9 September 2015

Our Ref: SE/CL/2015/38607/S

Application No:	14/02004/HYBRID (CDC) & 14/02063/OUT (WODC)
Site Address:	Land South of Perdiswell Farm, Shipton Road, Shipton On Cherwell, OX20 1QR
Proposal:	OUTLINE: Up to 1,500 dwellings, including affordable housing and up to a 150 unit care village (C2) with associated publicly accessible ancillary facilities; site for a new primary school; up to 930sqm of retail space; up to 7,500sqm locally led employment (B1/B2/B8) including link and ride; site for a Football Association step 5 football facility with publicly accessible ancillary facilities; public open space; associated infrastructure, engineering and ancillary works, (all matters reserved except for means of access to the development); and FULL: development of Phase 1 at the south western corner of the site for the erection of 29 residential dwellings (29 of the 1,500 described above) with associated open space, parking and landscaping; with vehicular access provided from Upper Campsfield Road (A4095), Shipton Road and Oxford Road (A44).

Open Space Strategy

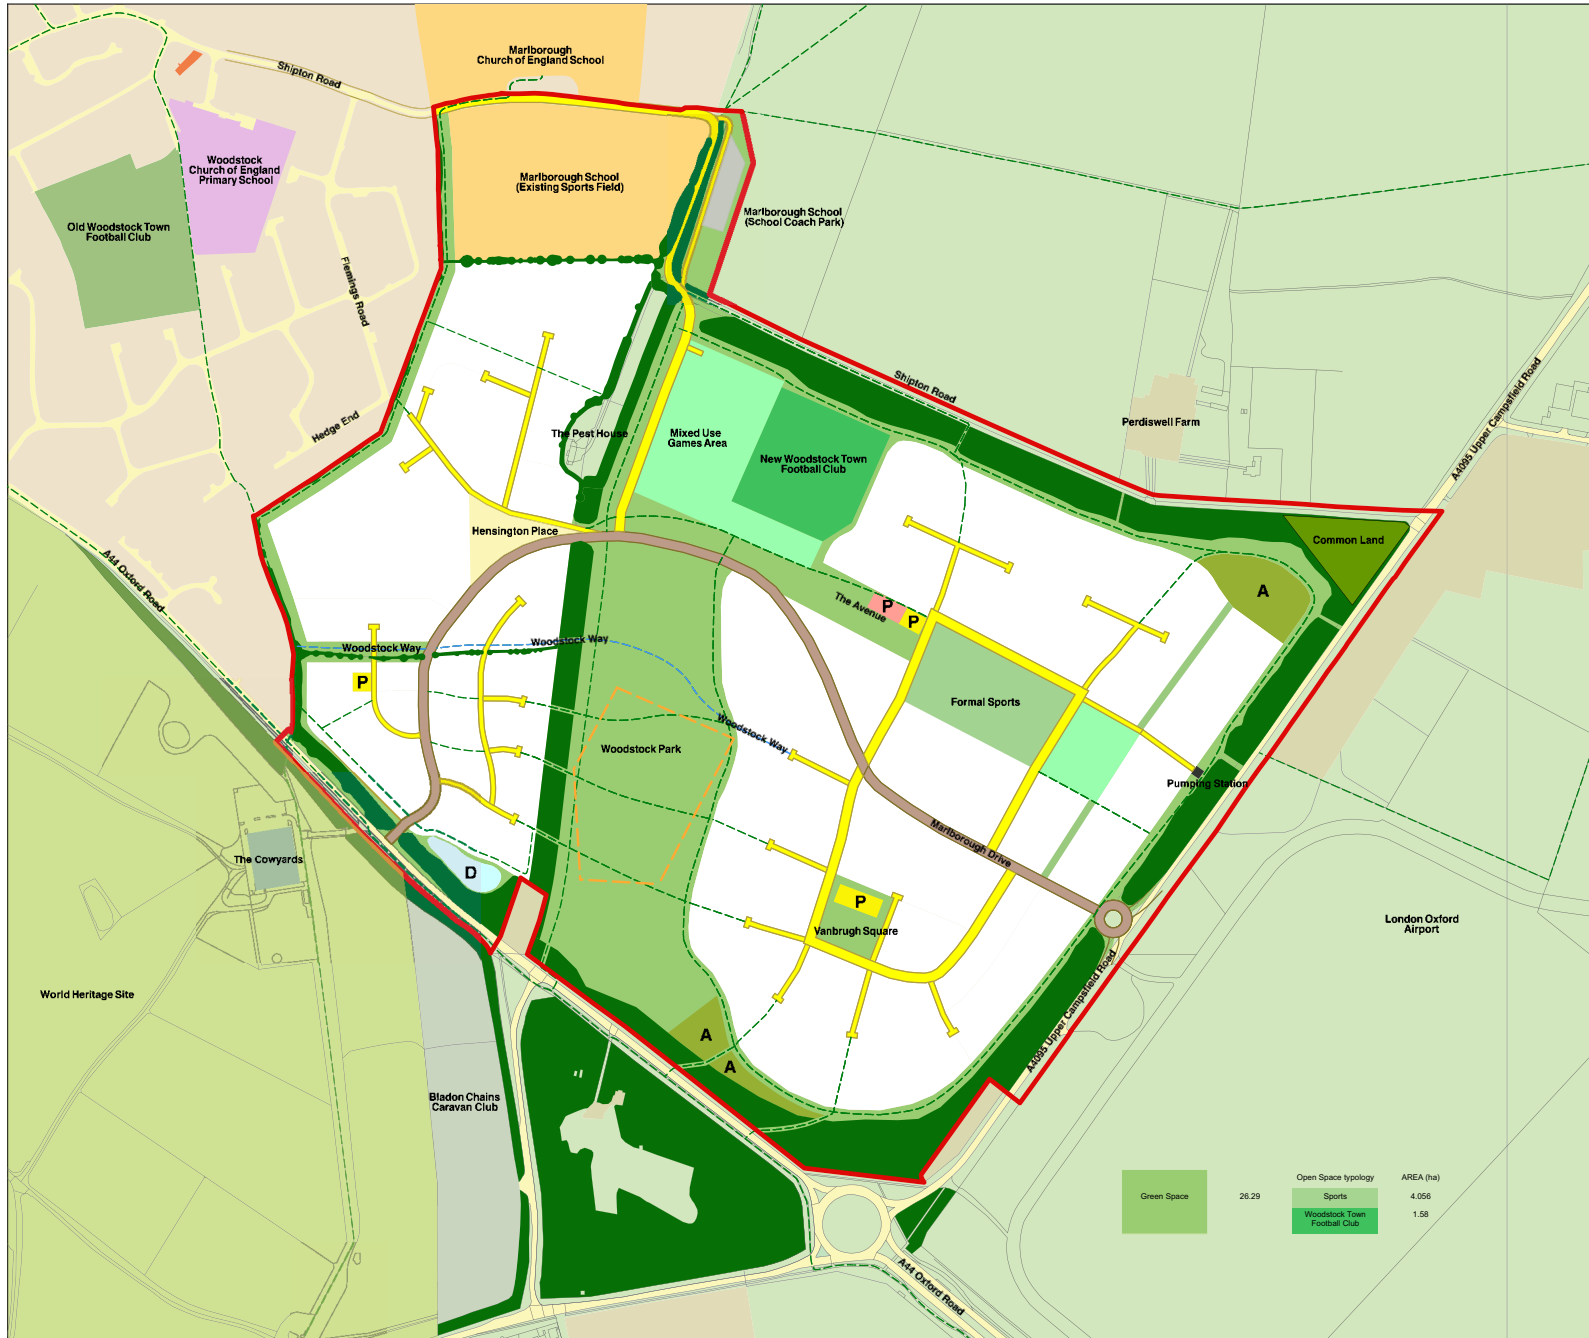
- b. The eastern areas of land identified for "*Formal Sports*" on the drawing numbered P112 are also described in the 'Design Response Document' as being suitable for "*less formal sports*" in one instance (p.53) and a "*Community Sports green*" in another (p.57). Therefore, it is unclear which sports are intended to be accommodated, whether changing

accommodation would be provided and how it would function satisfactorily as a sports ground, particularly with the two parcels of land separated by a “Secondary road corridor”.

It is unclear whether management will be the responsibility of BPE, the Marlborough School and/or the Football Club. The “*general principles*” are not set out. The “*relevant stakeholder*” is not identified. The “*principle*” that is “*strongly supported*” is unclear. It is also unclear whether the same arrangements will apply to the eastern areas of land identified for sport.
